Please consider this an observation submitted in response to the Newspaper Notice in the Connacht Tribune on 14/05/2026 related to Appeal Reference Number **ABP-320916-24**.

Long duration energy storage facility within an outdoor compound and a synchronous condenser positioned within a building and located within a second outdoor compound, together with all ancillary works. Environmental Impact Assessment Report and Natura Impact Statement submitted with application.

ABP-320916-24

Michael Gohery

Drawing file: MAPS 27-03-26 / CPA-HAL-MP-XX-DR-PL-1000 P10 Master Plan Layout New Access Road.pdf

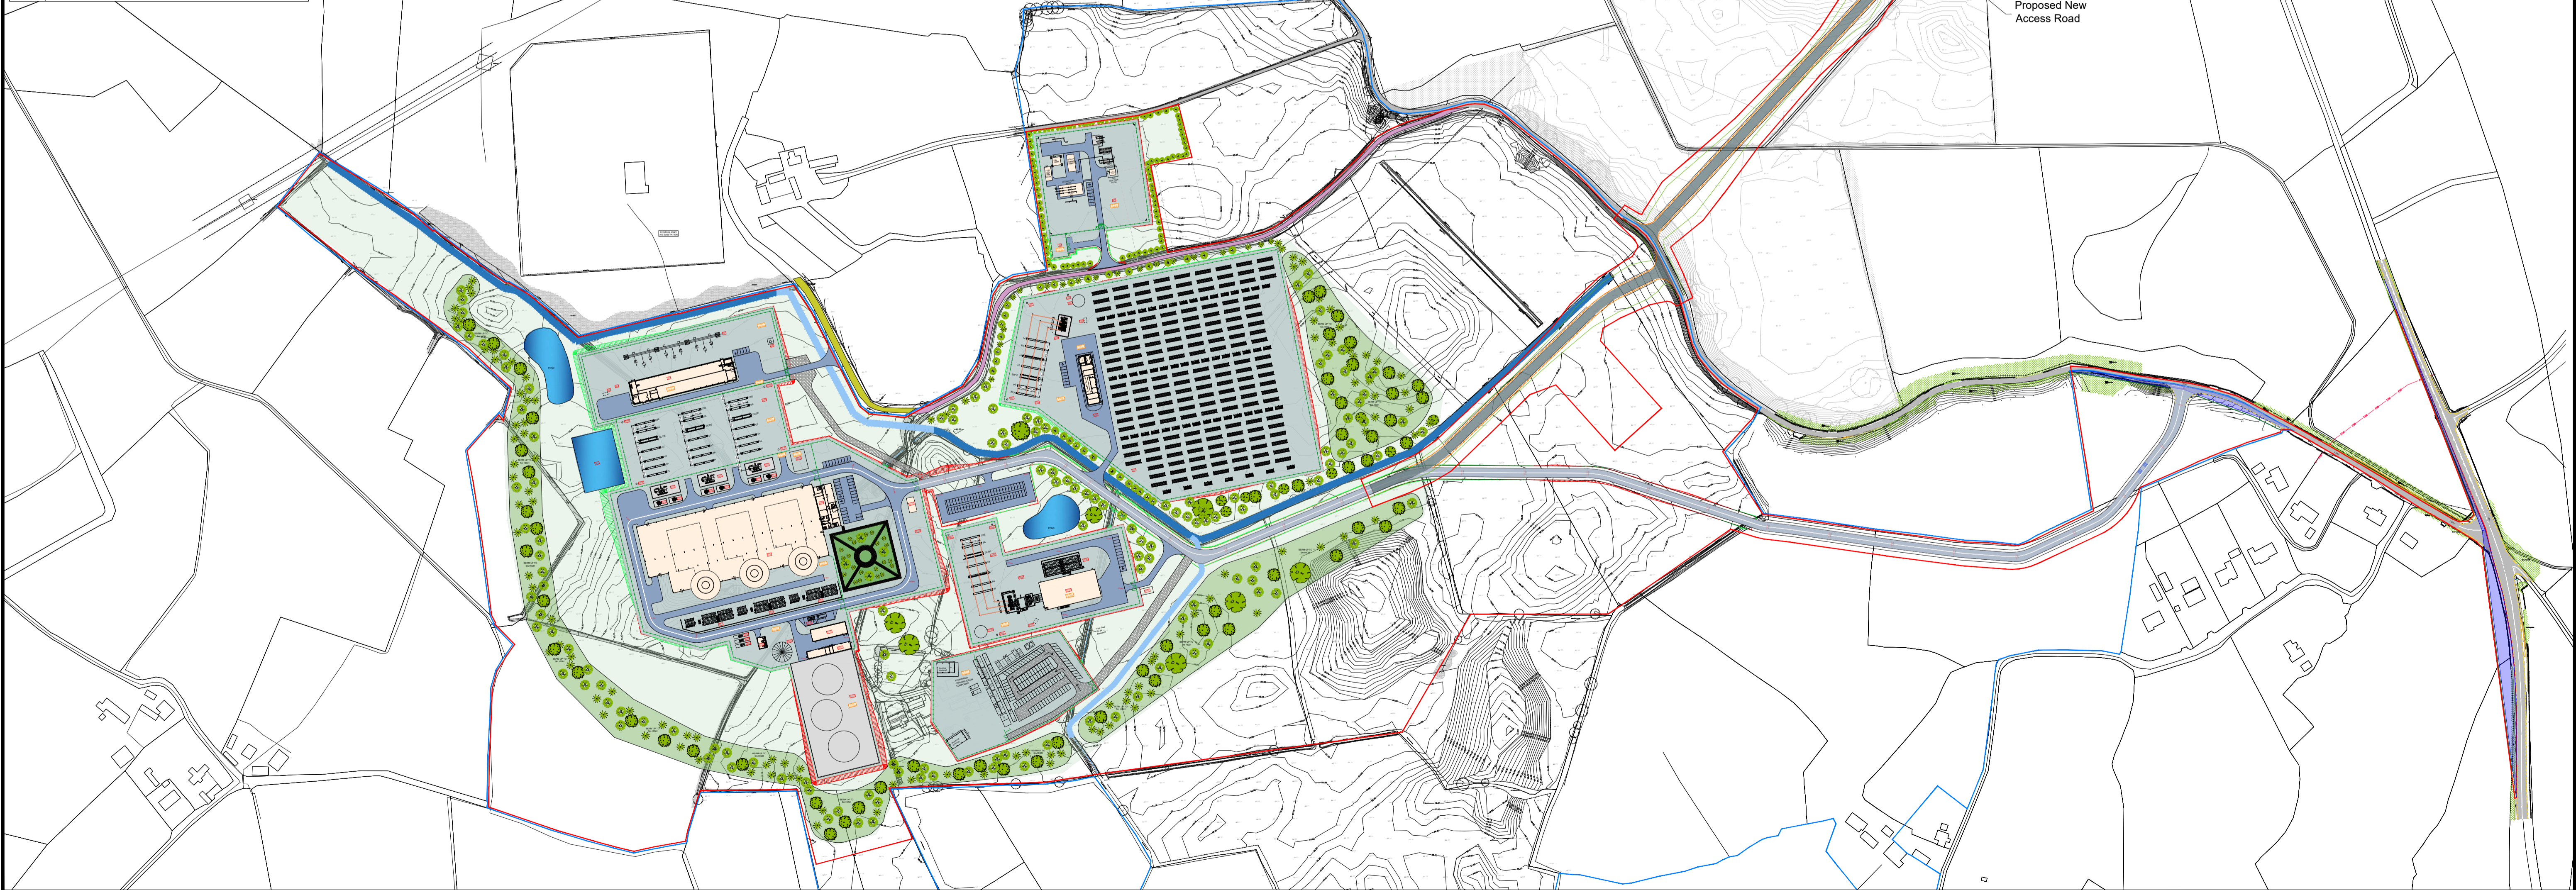
- That same report identifies rock that would require heavy breaking/blasting ranging from 41.8mOD to 52.8mOD. Most of the proposed buildings have a finished floor level of 51-52mOD¹¹. Therefore, the potential for encountering this hard rock is likely during construction. Noise and vibration pollution implications have not been considered in the developer’s EIAR and have not been adequately screened out.

- Table 7.2 of the EIAR²⁰ relates to the Synchron and adjacent parking area. According to R2 within the site investigation²¹, the existing ground level is approx. 52mOD. The proposed finish ground level is stated to be 53.1mOD²² approx. That is a required 1.1m of fill to the area. However, when the top 1m of poor ground is considered, 2.1m of fill is required to this area. The EIAR had calculated fill of just 0.04m to this area. That is less than 2 inches. The results of the corrected calculations are shown on the Table 1.0 below.
- Table 7.3 of the EIAR²³ deals with the cut and fill requirements for the LDES area. The table states that a footprint of 37,159.75m² will require fill of 20,055.52m³. That is an average of 0.54m fill to that footprint. That calculation appears very inaccurate.

- Table 7.4 of the EIAR²⁶ relates to the AGI area. According to R4 within the site investigation²⁷, the existing ground level is approx. 53.5mOD. The proposed finish ground level is stated to be 54.5mOD approx²⁸. That is a required 1m of fill to the area. However, when the top 1m of poor ground is considered, 2m of fill are required to this area. The EIAR had calculated fill of just 0.07m to this area. That is less than 3 inches. The results of the corrected calculations are shown on the Table 1.0 below.
